# WOODMOOR WATER AND SANITATION DISTRICT NO. 1

## WELL NO. 22

### SWMP, GRADING AND EROSION CONTROL PLAN

SHEET NO.  
**C1.0**

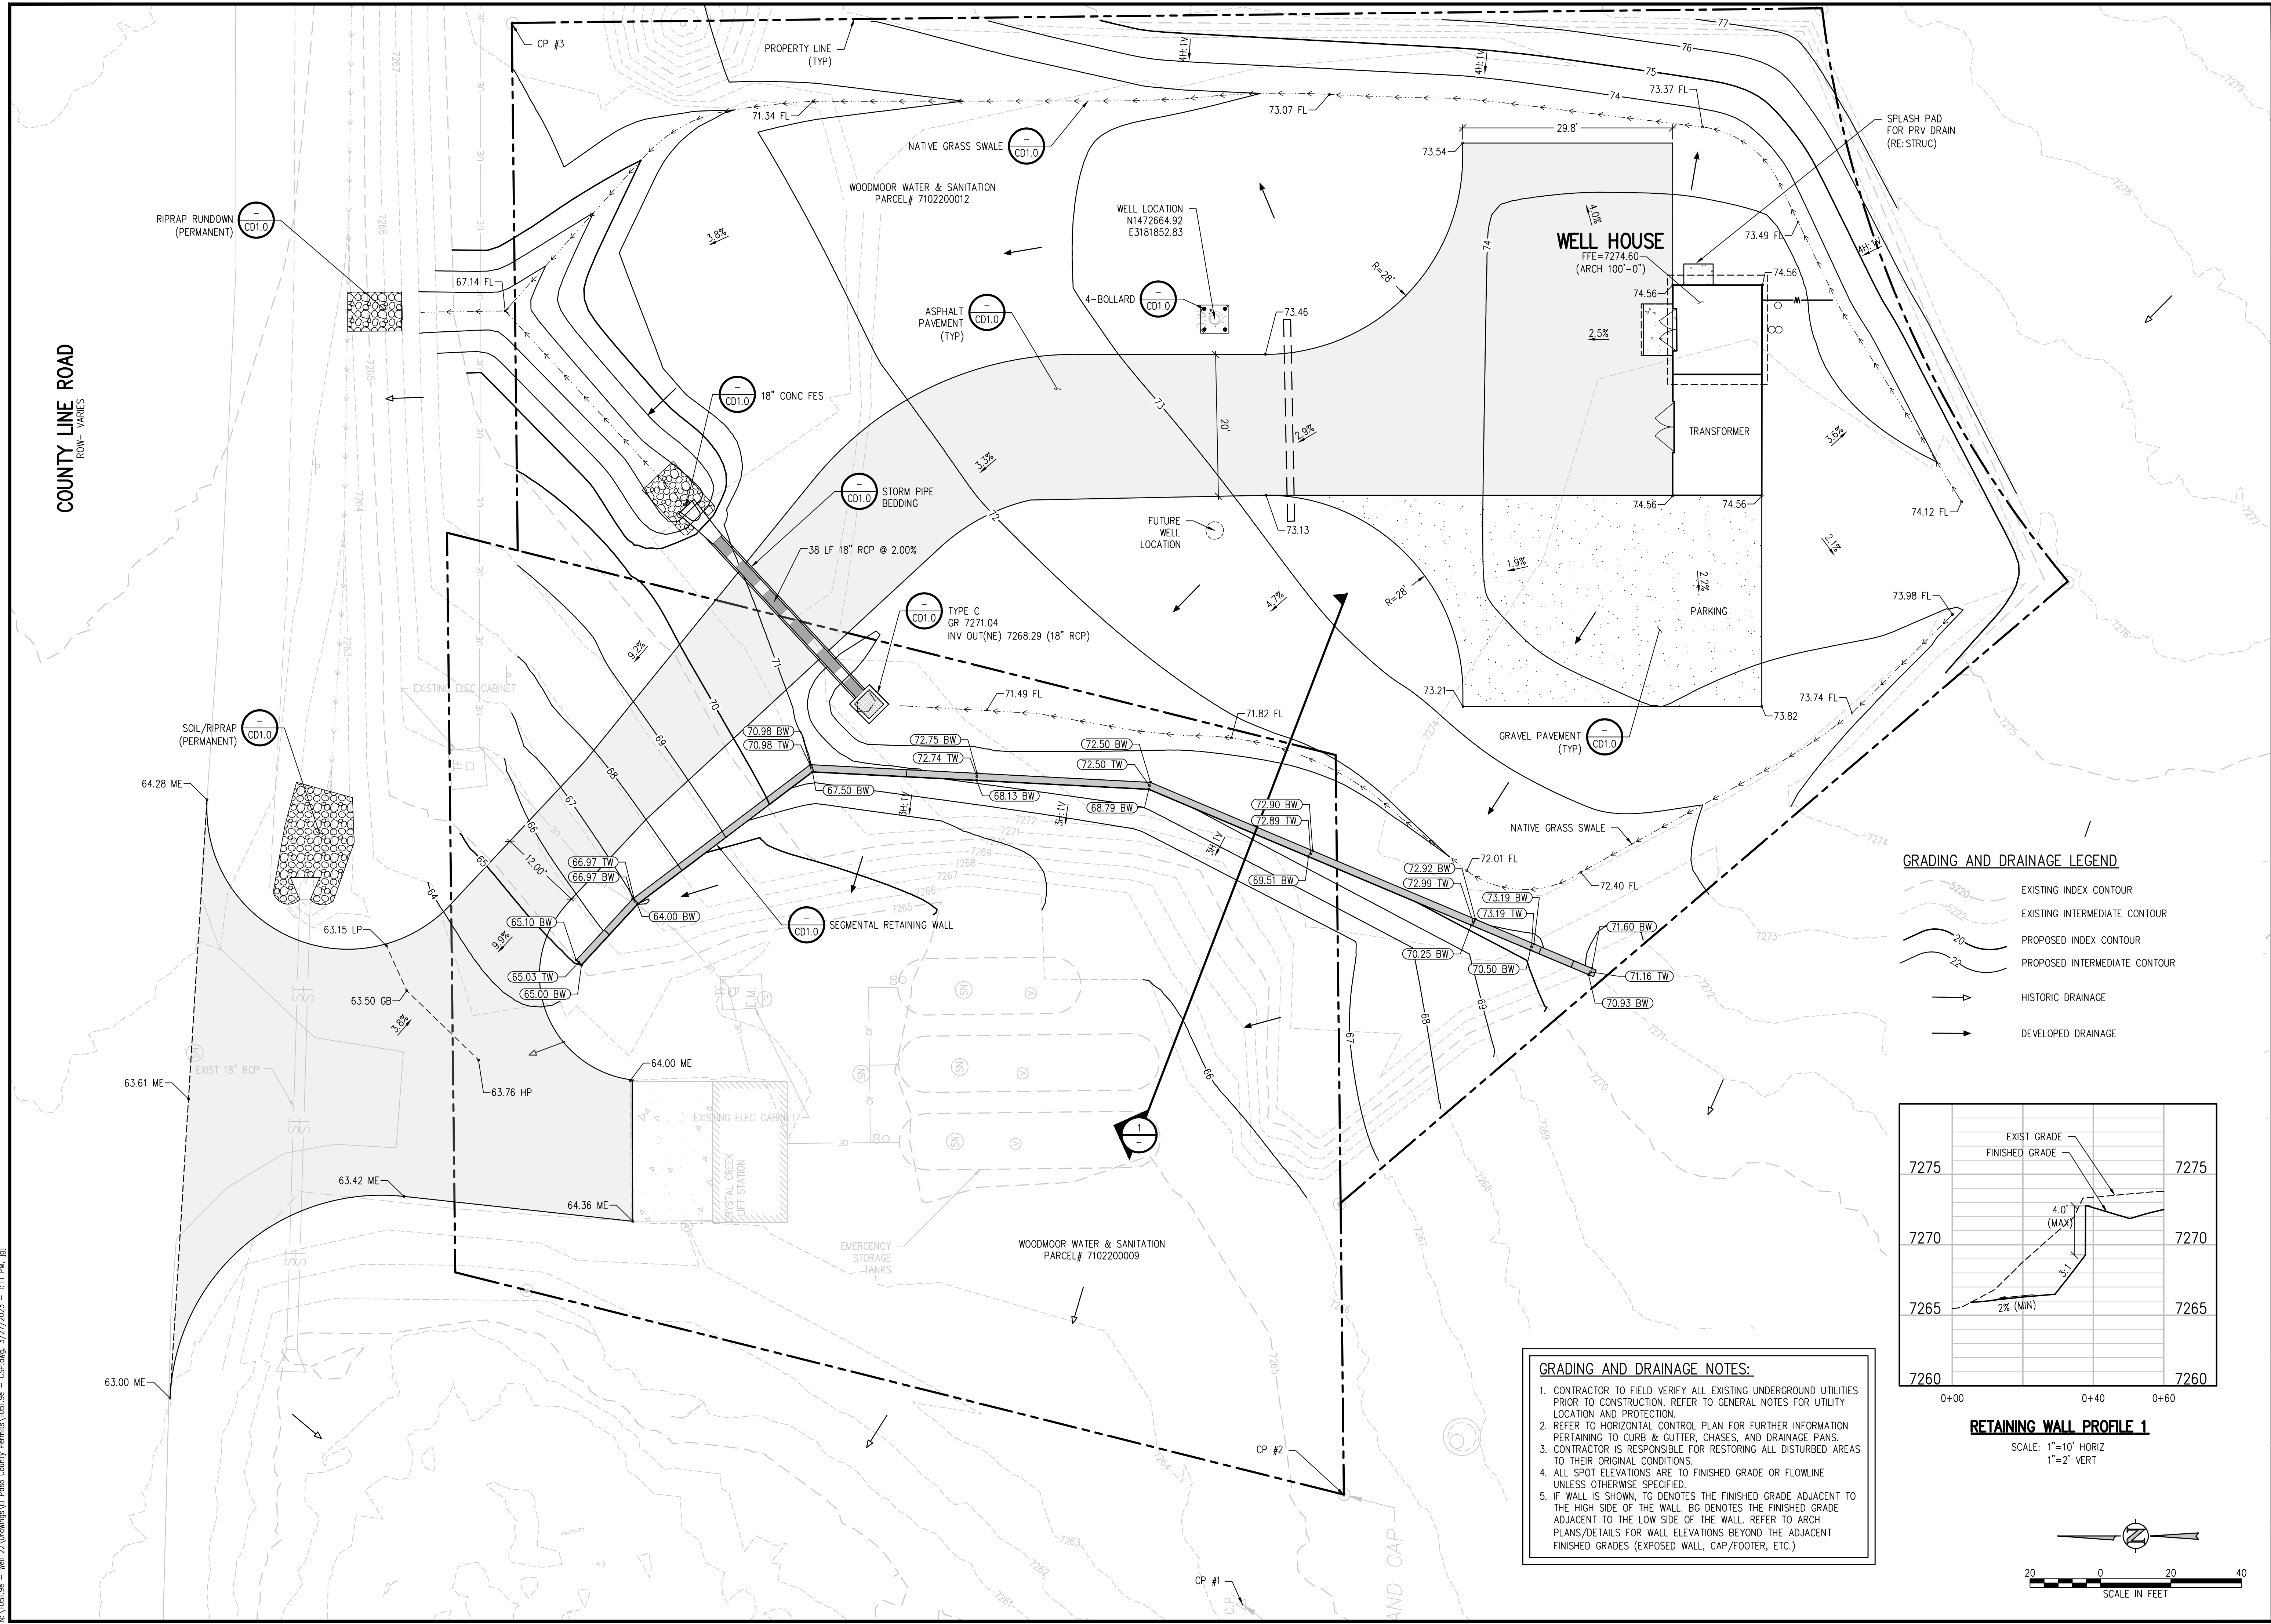
Unresolved from Submittal 1: Provide permanent riprap or other erosion protection in ditch at the discharge location.
